**KIRKLEES METROPOLITAN COUNCIL
INVESTMENT & REGENERATION SERVICE**

DELEGATED DECISION TO DETERMINE PLANNING APPLICATIONS

Reference No:	2024/62/90718/W
Site Address:	9, Springfield Avenue, Honley, Holmfirth, HD9 6ED
Description:	Erection of front and rear dormer windows and associated works
Recommending Officer:	Laura Yeadon

DECISION – REFUSED

PROPOSED FIRST FLOOR PLAN
SCALE 1:50

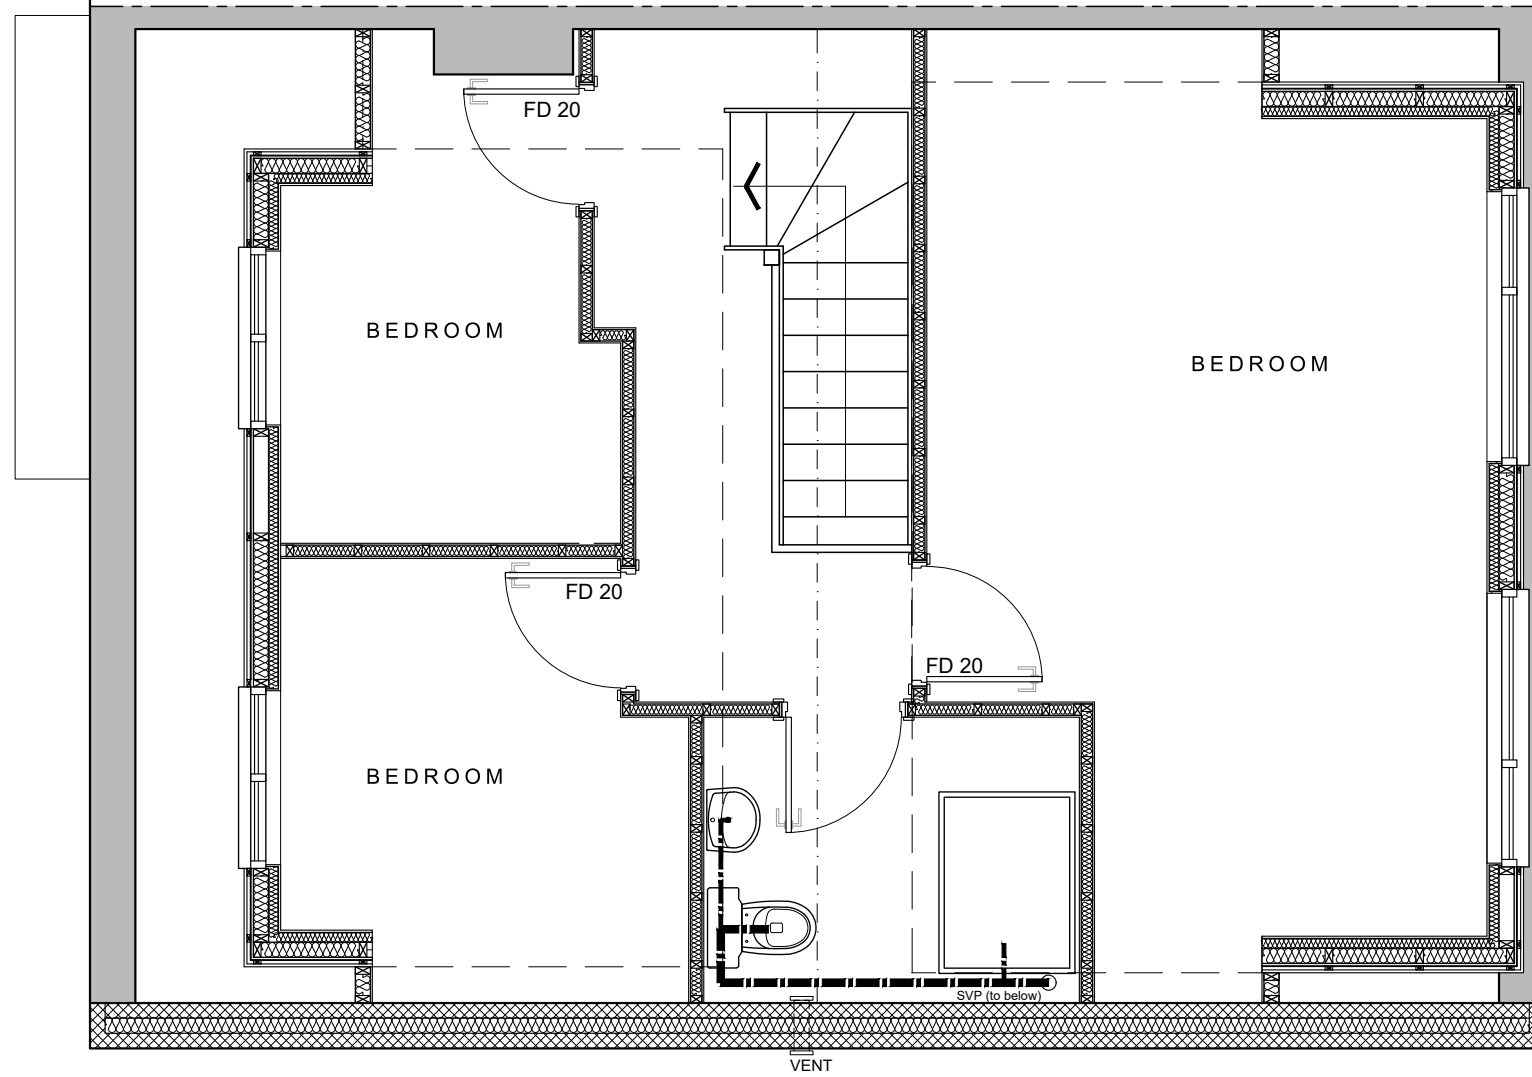
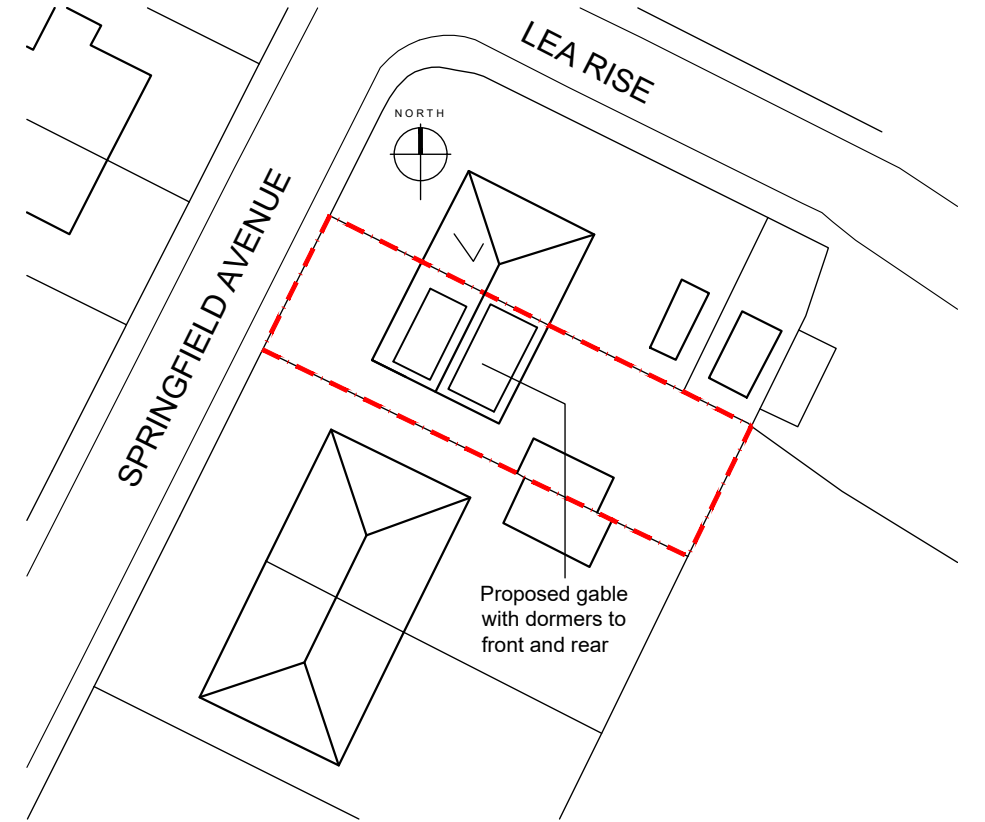
In this case the works would retain the existing garage provision however, it appears on plan that the garage space falls short of modern standards. The works would result in additional bedroom provision for the property which would result in a total of 3 no. bedrooms formed. As such, two parking spaces are required to be available which can be provided on the existing driveway. It is therefore considered that the works would comply with Key Design Driver 20 of the Highways Design Guide and Key Design Principle 15 of the House Extensions and Alterations SPD and Policies LP21 and LP22 of the Kirklees Local Plan.

PROPOSED ELEVATIONS
SCALE 1:100

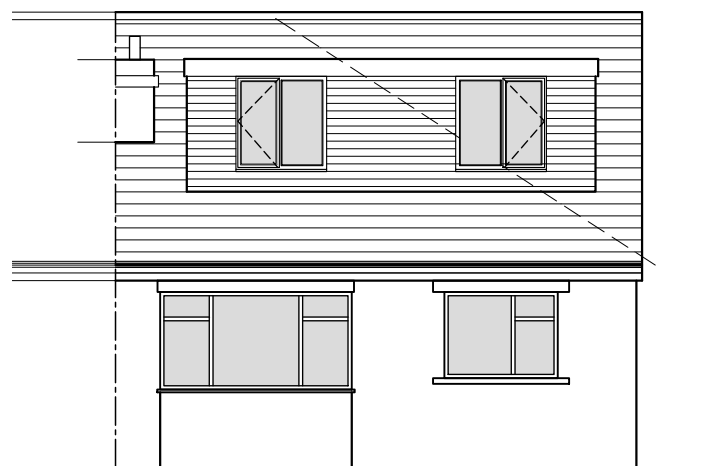
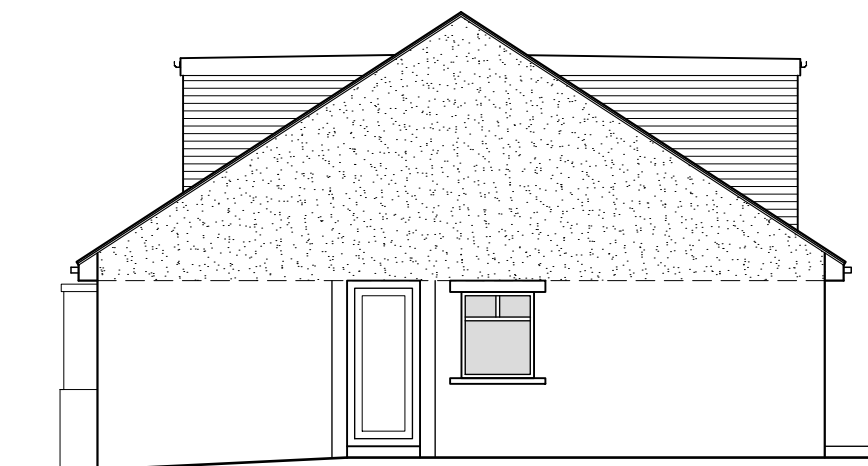
The scheme proposes a hip to gable roof extension, a front dormer extension and a rear dormer extension. The character of this part of the street scene is such that it is characterised by hipped roofed semi-detached single storey properties which are relatively uniform in roofscape with little interruption to the roof forms.

The proposed development would introduce a new roof form to the street scene and a front dormer extension which would be large in scale and would be an alien feature within the street scene whereby no other dormer openings are located within the front elevation roof slopes. Due to the change in roof form in addition to the front dormer, the development would be incongruous in relation to the character of the host dwelling and in the wider street scene and would not comply with the Council's adopted SPD.

In terms of reference to the specifics of the SPD the hip to gable roof form and front dormer would not relate to the appearance of the house and existing roof as a new feature would be introduced which cumulatively when taking into account the development as a whole would dominate the roof form and would not be considered subservient. Therefore, it is not considered that the works would comply with paragraph 5.27 of the SPD or Policies 1 and 2 of the Holme Valley Neighbourhood Development Plan.

When taking the development as a whole into consideration, the works, in particular the front dormer extension and hip to gable extension would result in alterations to the roof form which would appear incongruous by introducing alien features into the street scene whereby there are no other such features at present. Due to the cumulative size, scale and siting, the development would result in a development which would alter the street scene where the roof slopes are uniform in design and introducing alien features where none are currently evident.

1. The proposed hip to gable roof alteration and front dormer extension would result in overly prominent and incongruous features being introduced to the street scene. Cumulatively, due to the size, scale, siting & design of the works as a whole, the hip to gable roof alteration and front dormer extension would have a harmful visual impact upon the host dwelling and wider street scene. The proposed works would therefore be contrary to Policies LP24 (a and c) of the Kirklees Local Plan, Key Design Principles 1, 2 and detailed guidance within Section 5 of the Council's adopted House Extensions and Alterations SPD, Policies 1 and 2 of the Holme Valley Neighbourhood Development Plan and policies within Chapter 12 of the National Planning Policy Framework.
